The Woodland Trust

Planning Application - 24/00539/F

Land East of Stratfield Brake and West of Oxford Parkway Station (known as 'The Triangle')
proposal for a stadium for Oxford United Football Club (OUFC).

Figure 4.8 - Hard and Soft Landscaping Plans

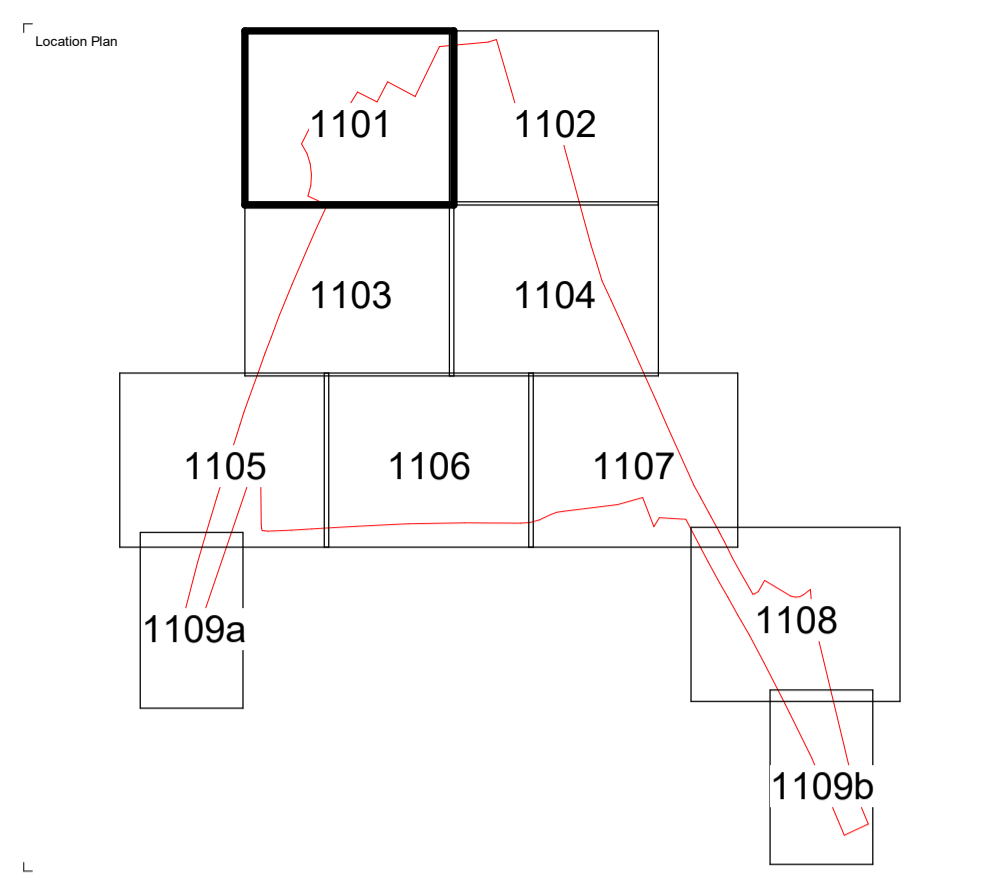
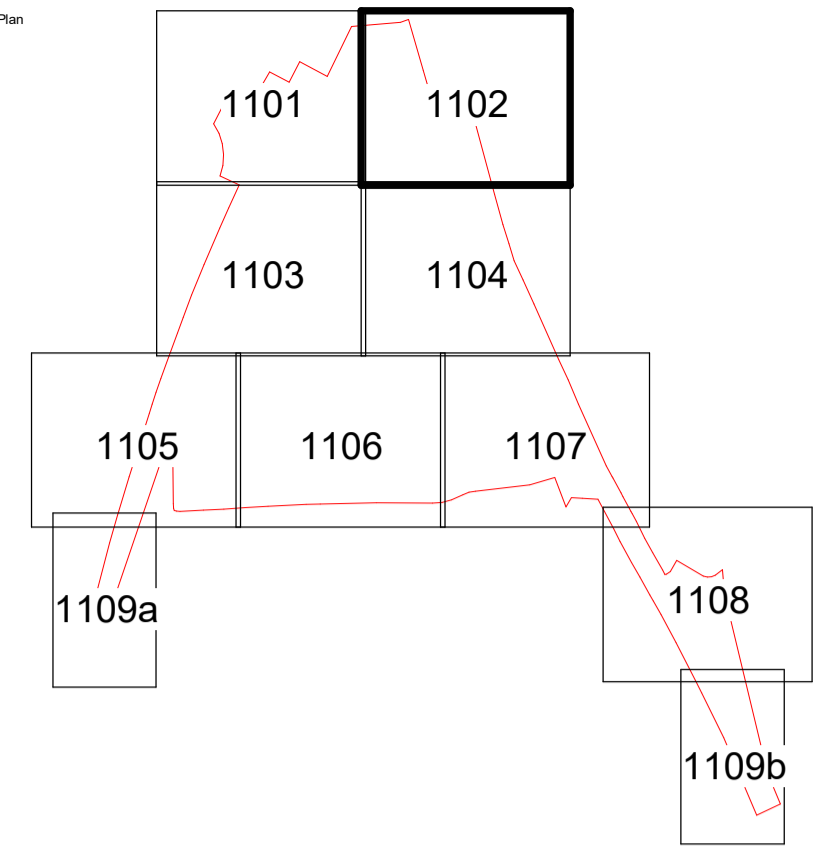
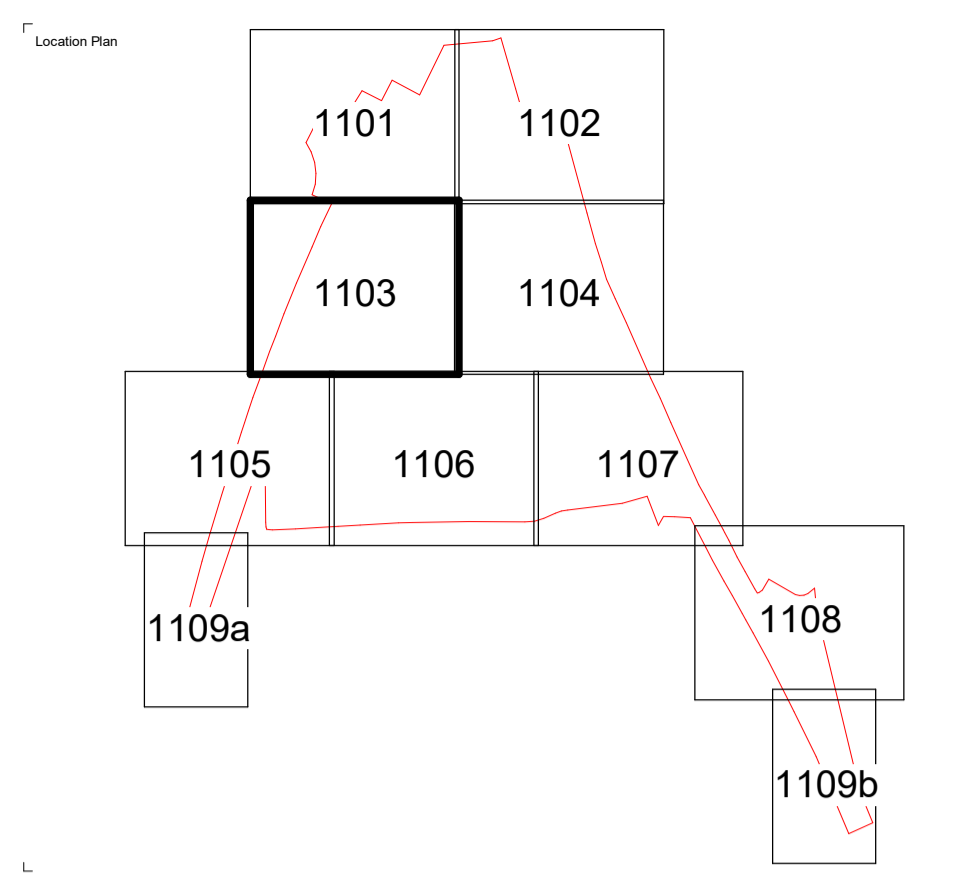
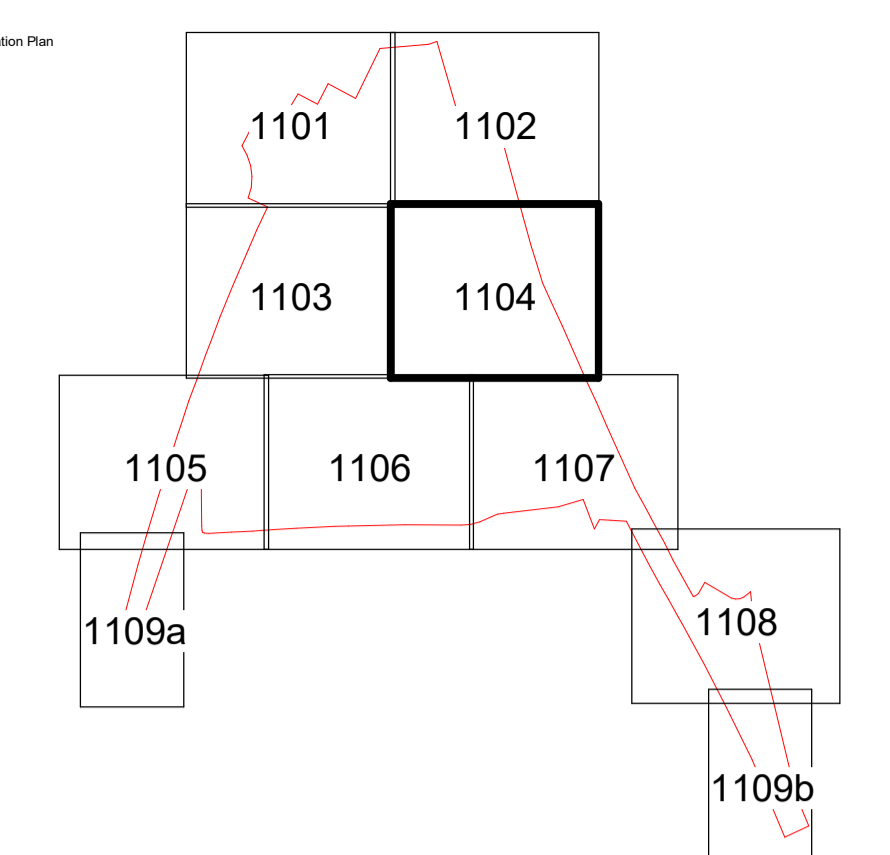
We note the application states that 143 new trees would be planted within the site, including 81 trees of extra heavy standard or above, approximately 2,000m² of scrub planting and 350 linear metres of native hedgerow. We ask that this **planting is secured by planning condition** and that the trees selected are **native tree species from UK sourced and grown stock**, for biodiversity resilience and biosecurity.

We are concerned to see that the plans propose the removal of some established trees, including two TPO oak trees on the eastern boundary of the site. We ask that the **retention of these important trees** be required and secured by planning condition.
